Rezoning Transportation Analysis

Petition Number: 2020-141

General Location Identifier: Tax ID 12708701

Date	Description
10-26-20	First Review

RZ-100

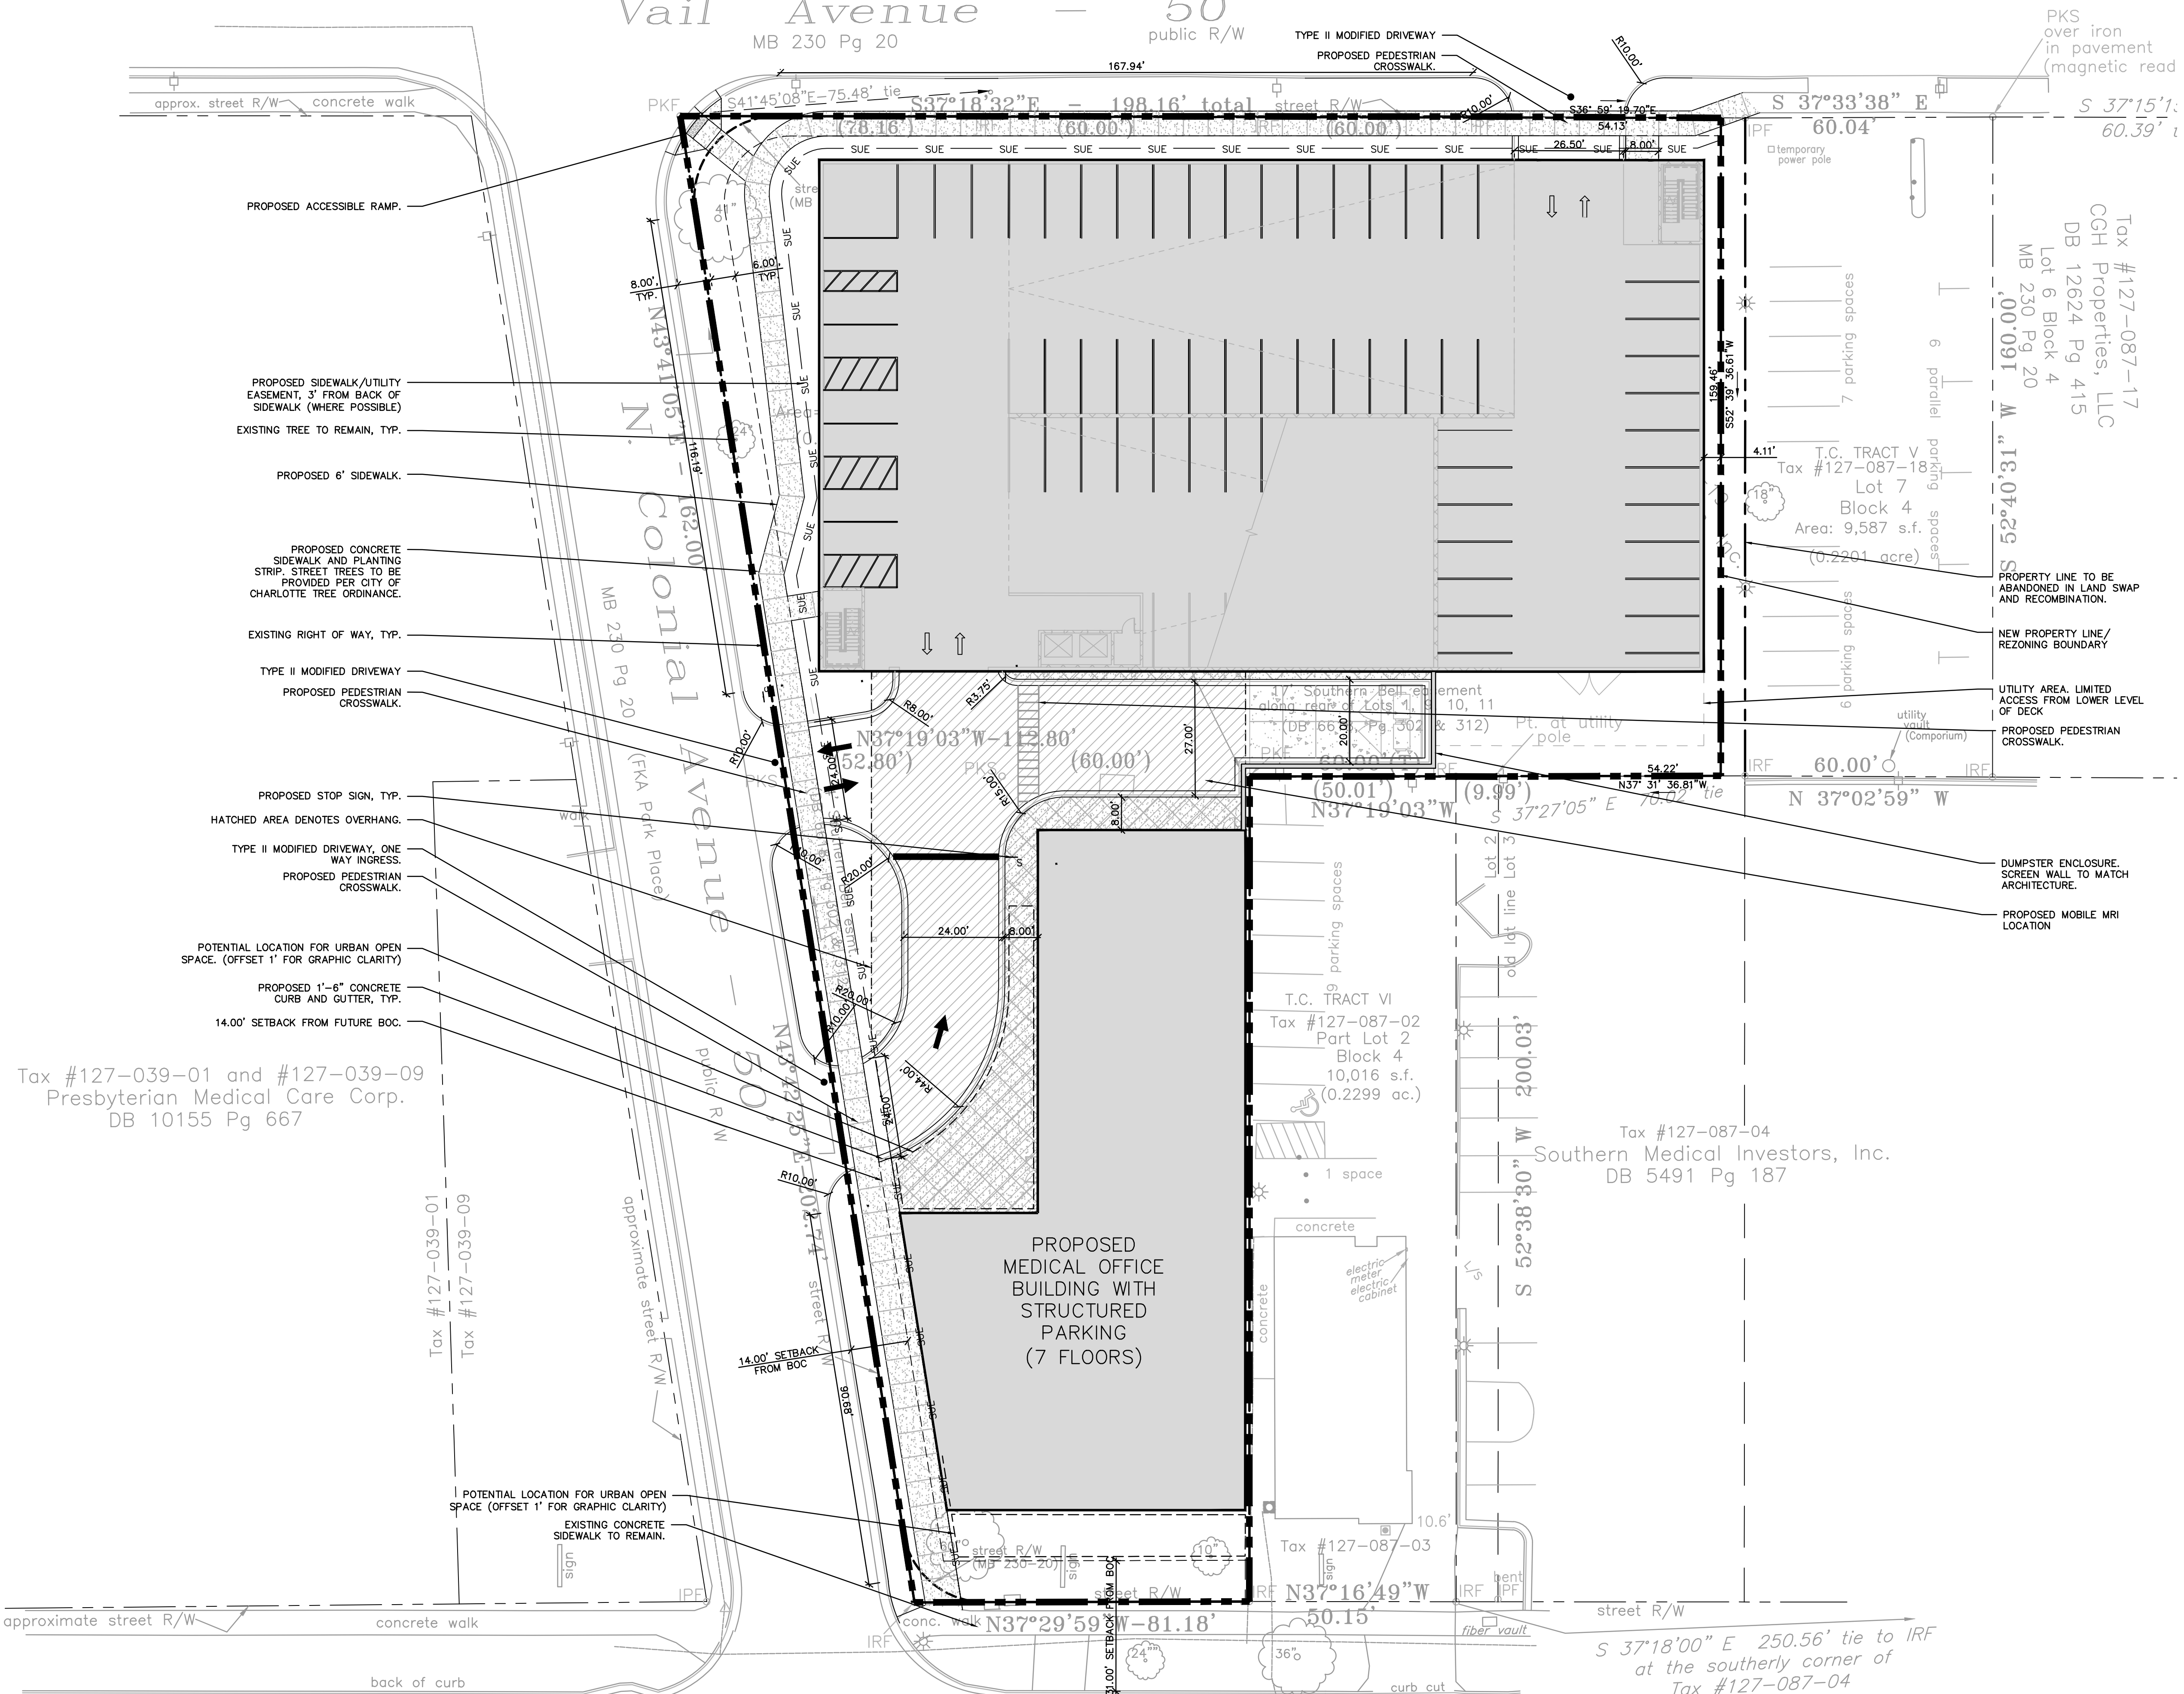
1. **Curblines:** The proposed zoning district has a setback measured from back of the existing or proposed future curblines.
 - a. **Randolph Road:** The future location of curb and gutter is in its existing location.
 - b. **Vail Avenue:** The future location of curb and gutter is in its existing location.
 - c. **Colonial Avenue:** The future location of curb and gutter is in its existing location.

Label and dimension curb and gutter from the centerline for each road on the site plan.

3. Revise site plan and conditional note(s) to commit to constructing an 8-foot planting strip, and 8-foot sidewalk along the site's frontage per Chapter 19. The wider sidewalk also meets the Charlotte WALKS Policy.
4. Revise site plan and conditional note(s) to commit to constructing two ADA Curb ramps per intersection quadrant in accordance with the ADA law and PROWAG. The site plan shall label and dimension these items from the back of curb and gutter.
